**RE: View House Apartments
540 Paisano Ct. NE
Grading and Drainage Plan
Engineer's Stamp Date: 1/17/22
Hydrology File: D17D074**

Based upon the information provided in your submittal received 1/4/2022, the Grading & Drainage Plan is **not** approved for Building Permit. The following comments need to be addressed for approval of the above referenced project:

CG-101

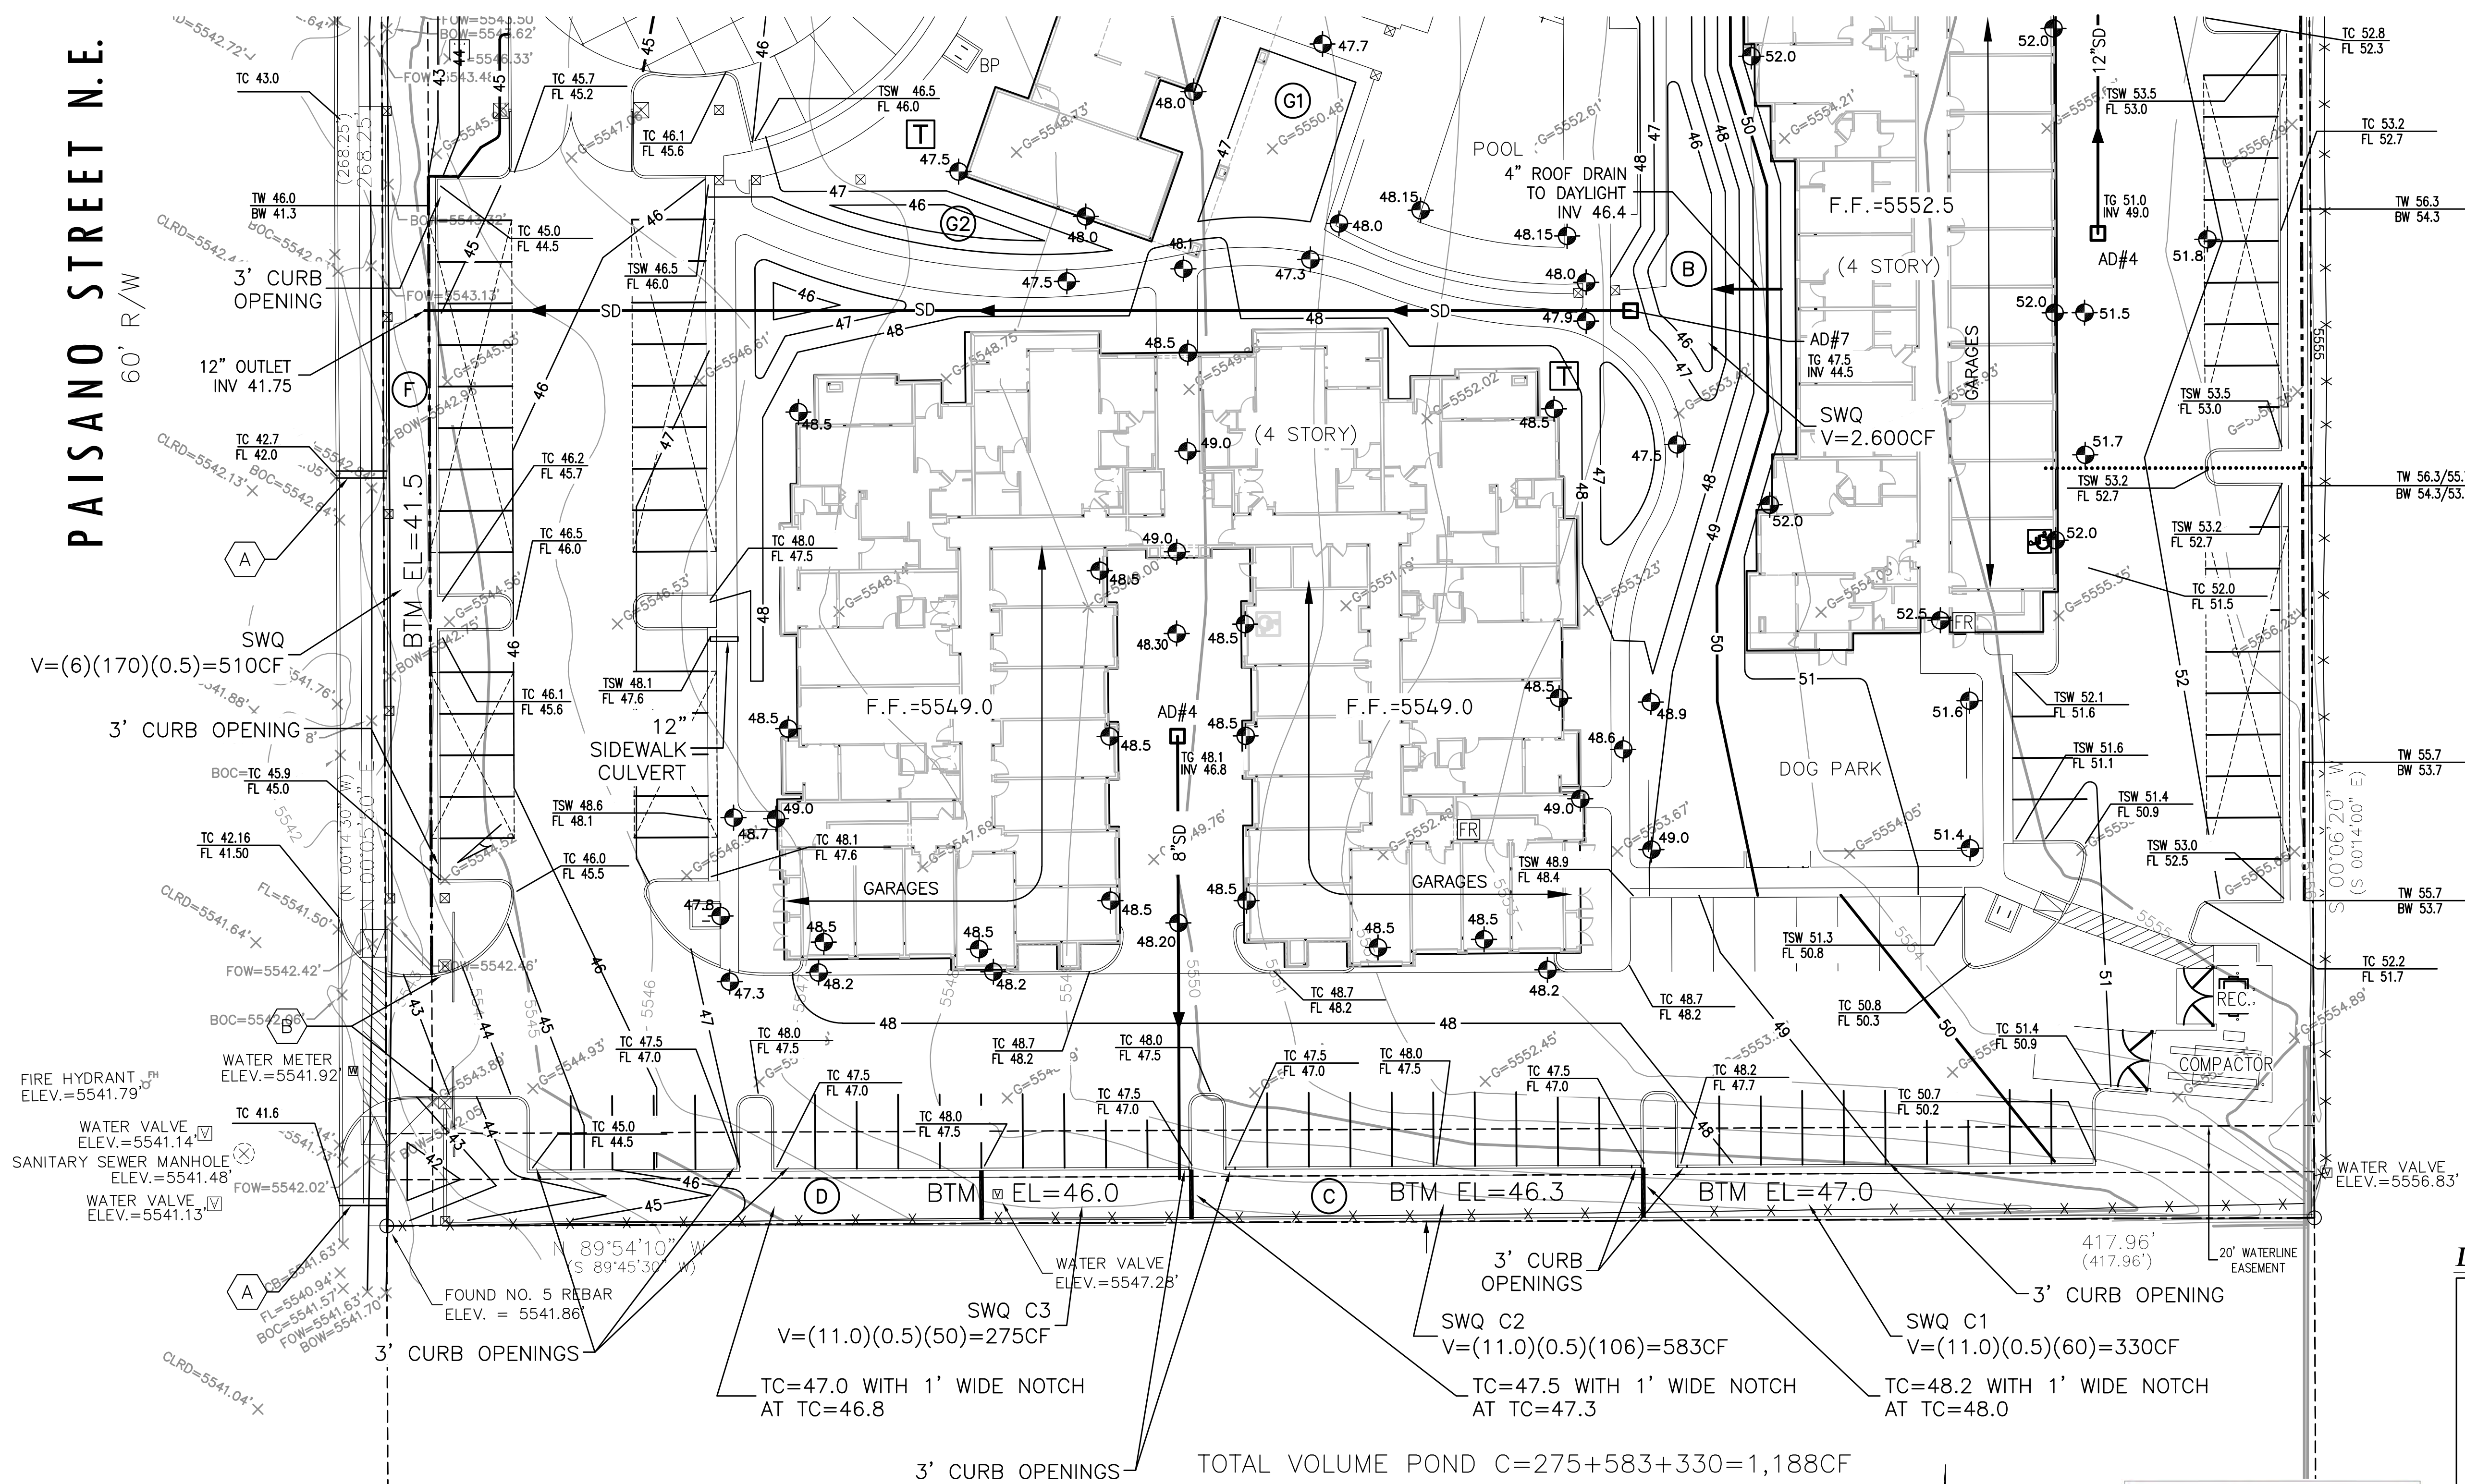
6. Please include weir calculations for curb openings.
7. Please include SO-19 notes. (see attached in email)
8. Please label high points and as mentioned above delineate the basins.

11. Please include note:
 - a. Please add a note under Grading Notes. "Side slopes need to be stabilized with Native Grass Seed (per City Spec 1012) with Aggregate Mulch or equal (Must satisfy the "Final Stabilization criteria" CGP 2.2.14.b.)".
